RE: **Old Dominion Freight Line - 330 Airport Road NW**
Grading & Drainage Plan and Drainage Report

File **K10-D008A**
PE Stamp: 2/27/13

Based upon the information provided in your submittal received 2/ 27/2013, the above referenced plan is **ONLY approved for Site Plan for Building Permit action by the DRB.** This plan cannot be approved for Grading Permit or Building Permit until the following issues are addressed:

Sheet Name:  
GRADING AND DRAINAGE PLAN

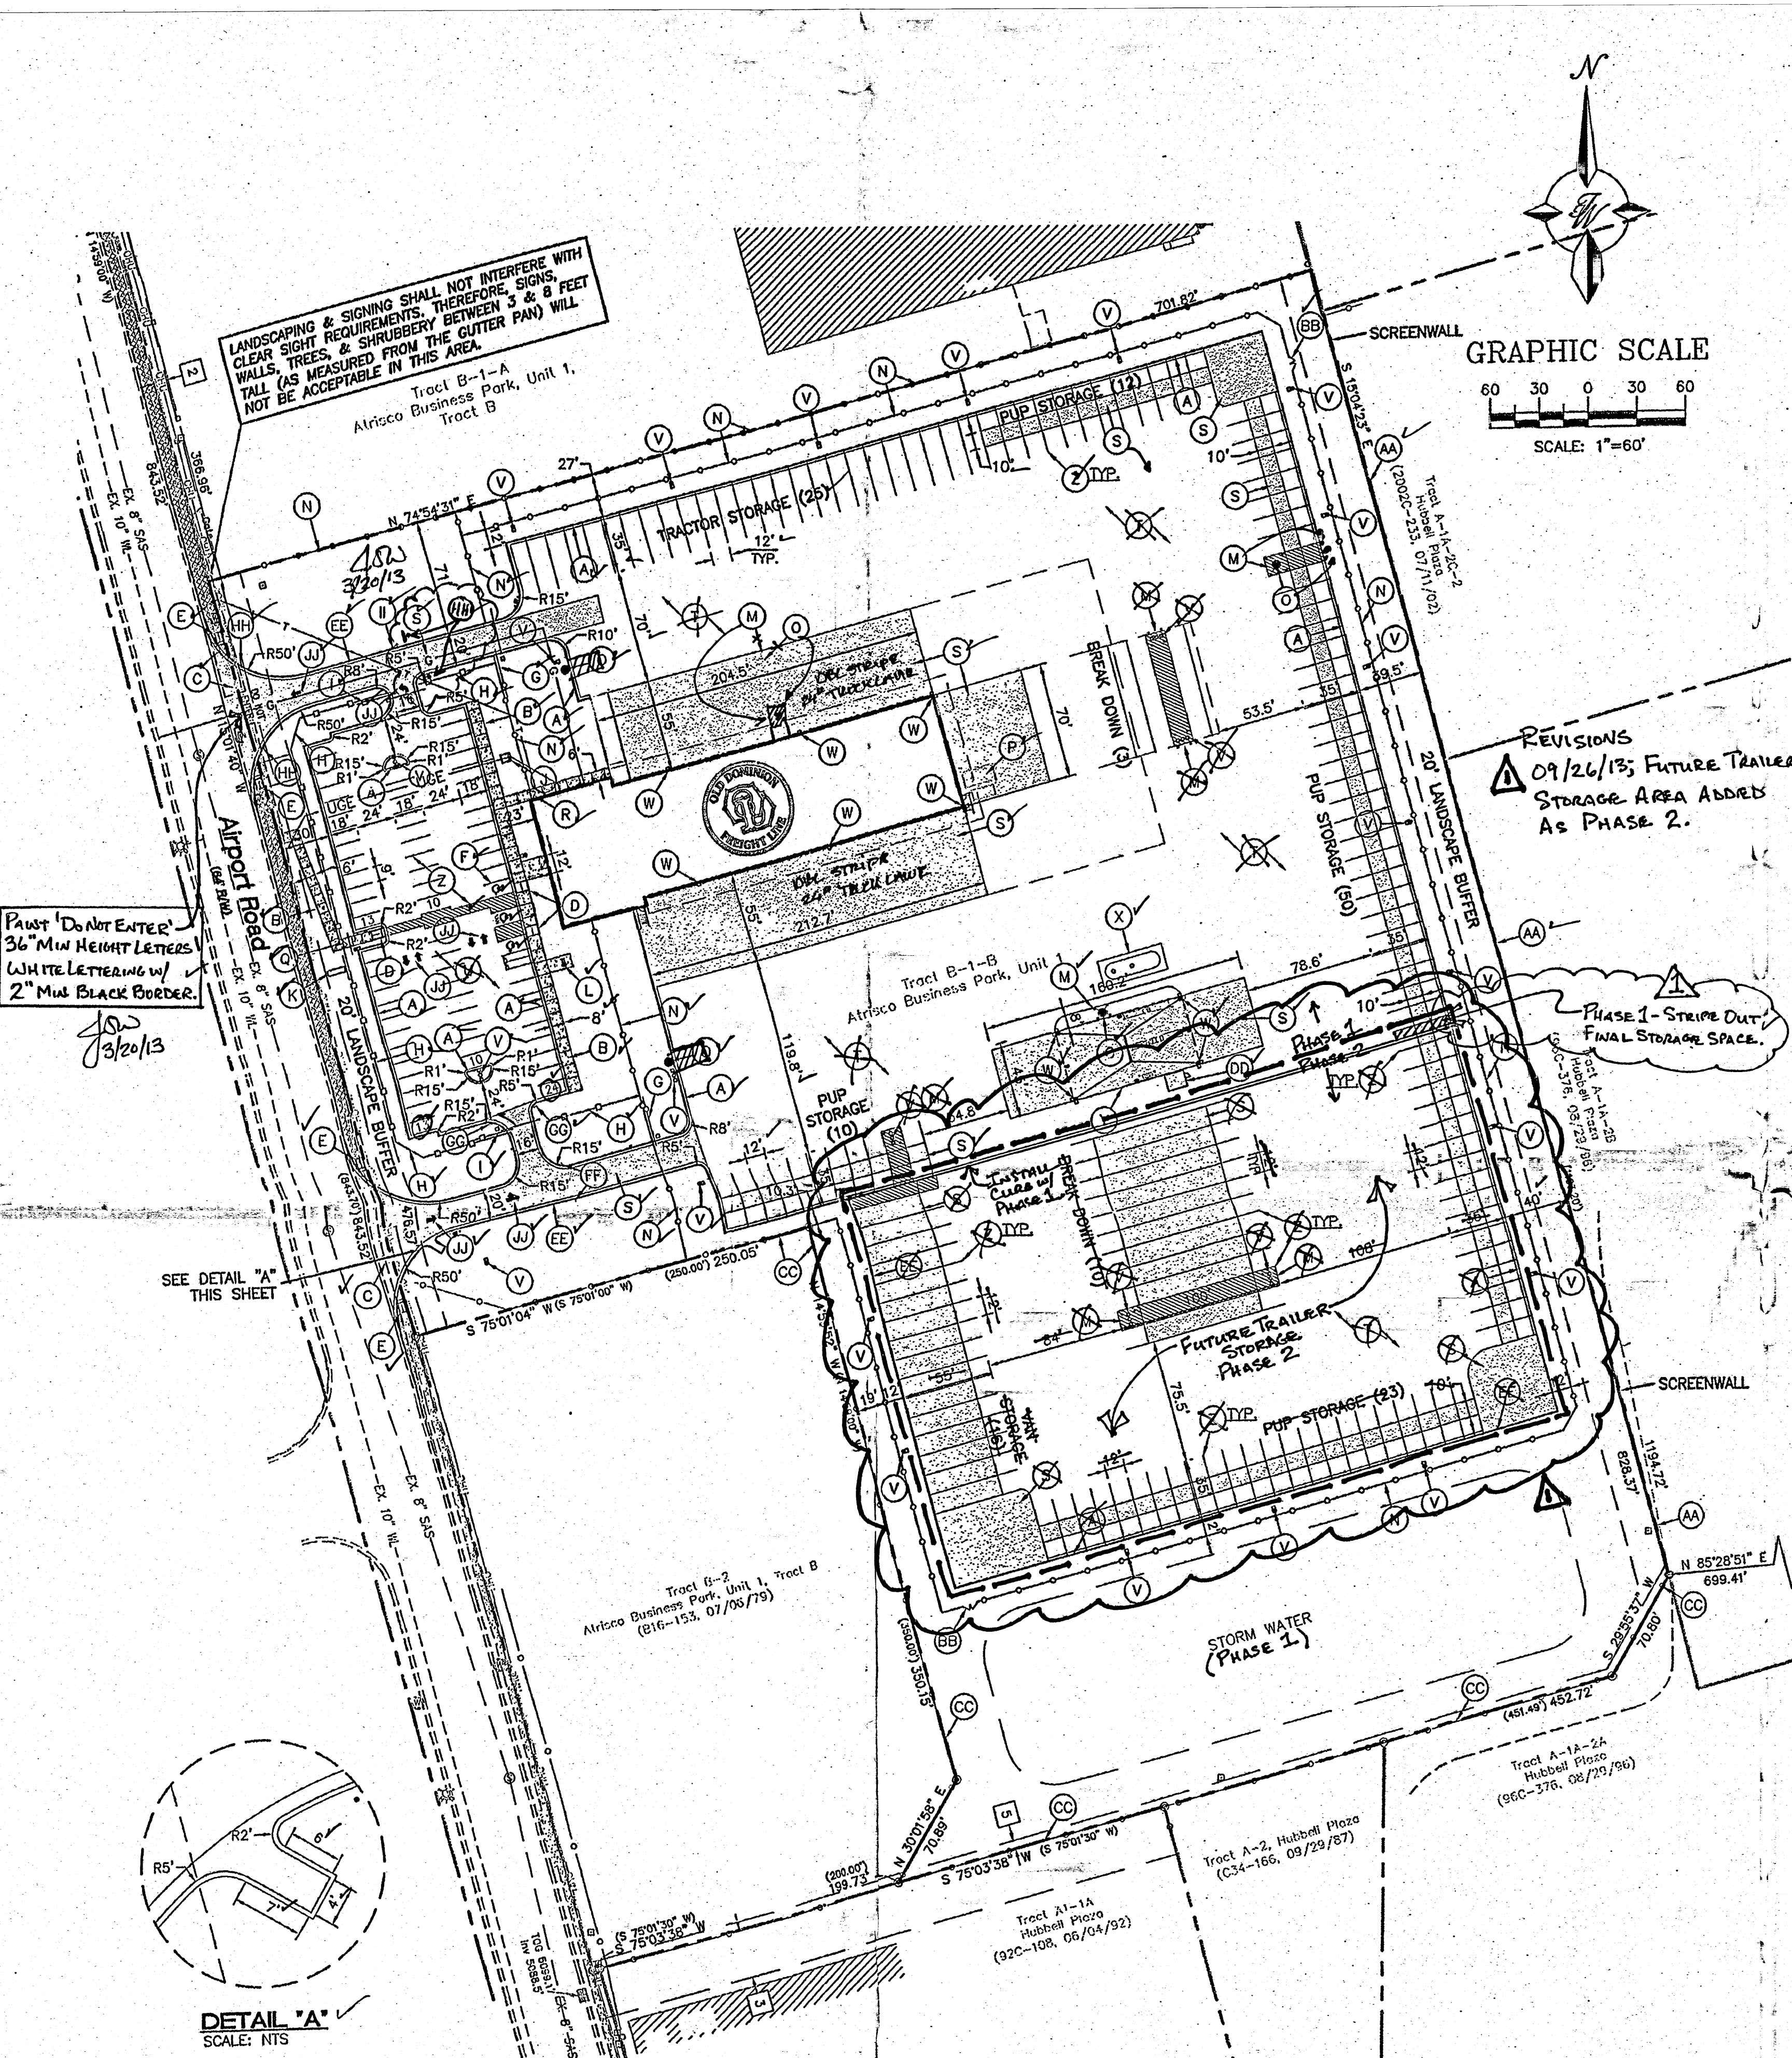
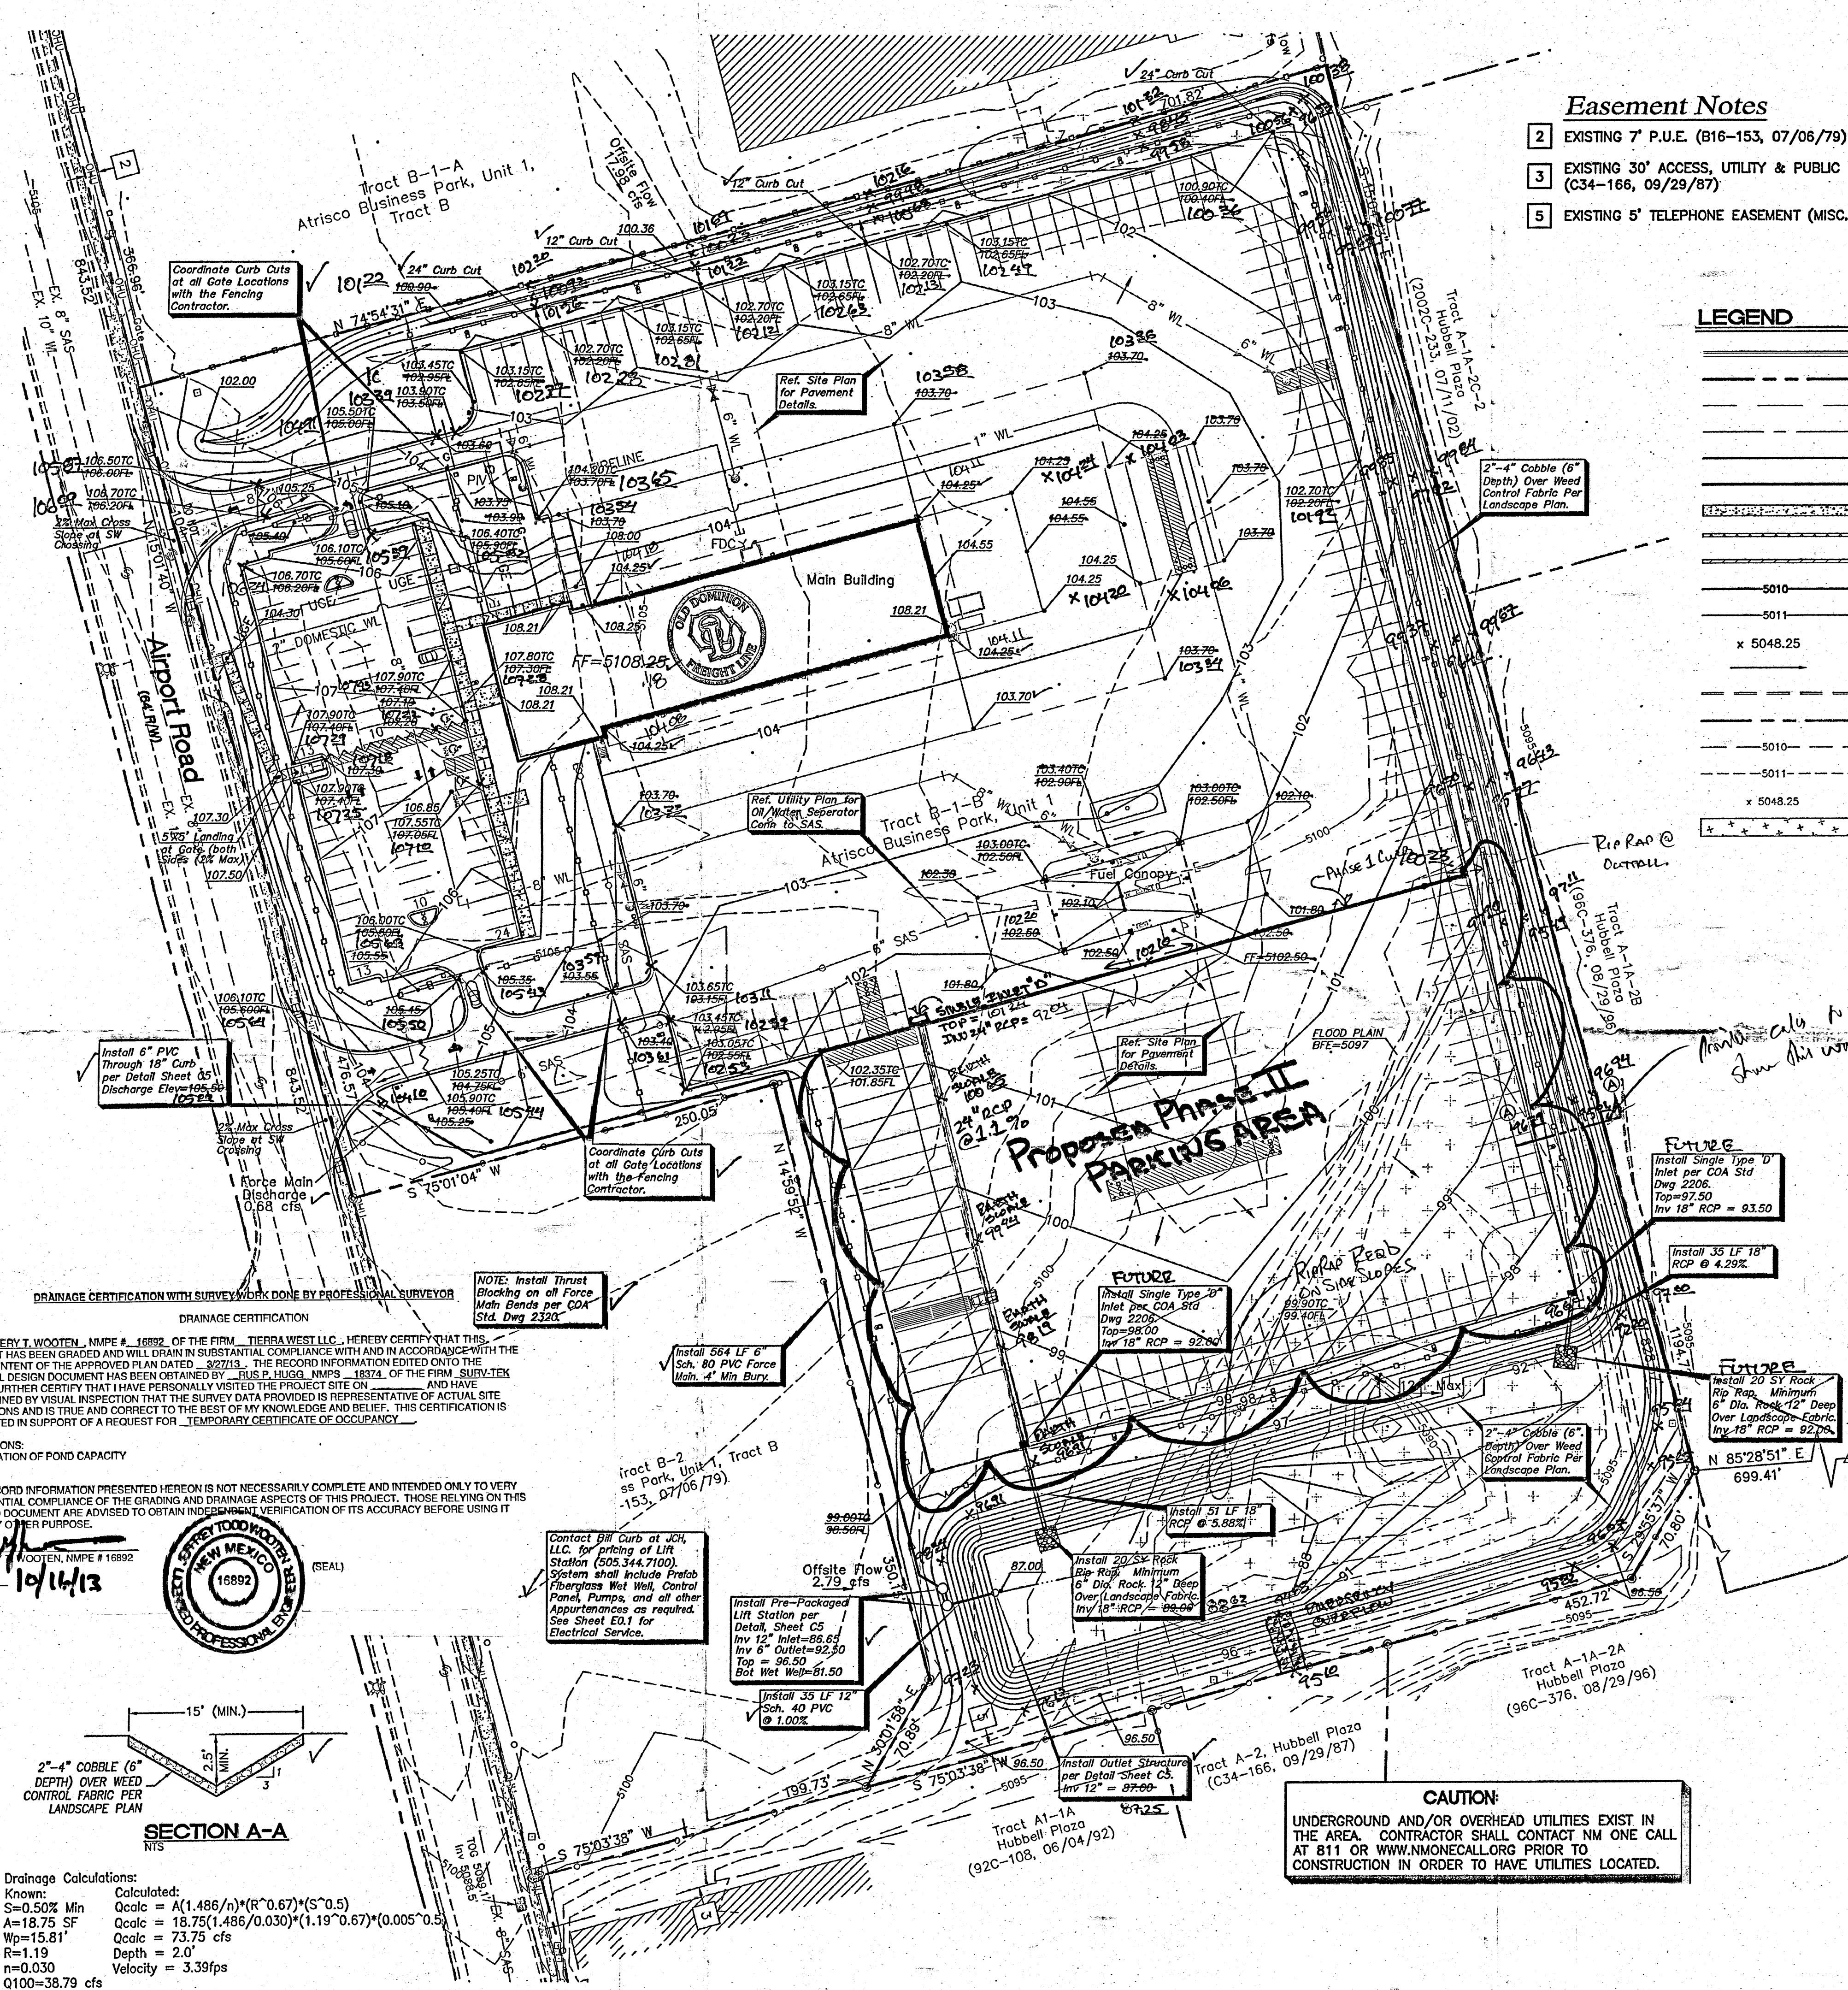
1. The report confuses Tracts B-1-A and B-1-B, and actually shows B-1-A as part of the site in the vicinity map. Please clarify.
2. The proposed gravity drain line from the detention pond, through the off-site easement is not acceptable, without dedication of a "Private Storm Drain Easement." Jeff's verbal, alternate proposal is acceptable, to provide a pumped discharge from the pond to a surface discharge point at a drivepad or sidewalk culvert. Provide details of this design, including pump and line sizing, and SO-19 if appropriate.

3. Show flow arrows and rates where off-site flows enter the site, and the proposed, pump discharge flows leave the site.
4. Label (or identify by legend) the surface treatments, pavements, landscape treatments, erosion control details in the perimeter swale, etc.

5. Label major site features, such as buildings, fueling islands, oil-water separator, etc. Show how the Oil-Water separator will drain.
6. Since the pond has no designated "Emergency Overflow," the pond volume should be designed to accommodate the 10 day storm volume. As discussed, surcharging that surplus volume into the paved parking area may also serve as an indicator to the owner, when pond maintenance is needed.

7. The drainage plan shows 0.88 cfs being free discharged onto Airport Road along the NW edge of the site. This flow should at least be routed through depressed landscape area(s), harvest the first 0.44-inch of rain, and the resultant discharge rate must be included in the site limit of 0.1 cfs/acre. It may be appropriate to detain some of the off-site flows from the north in the landscape strip along the northern boundary, and even divert some of that flow to Airport Road.
8. The First Flush Volume table in the report is miss-labeled as 0.43 cu. Ft.
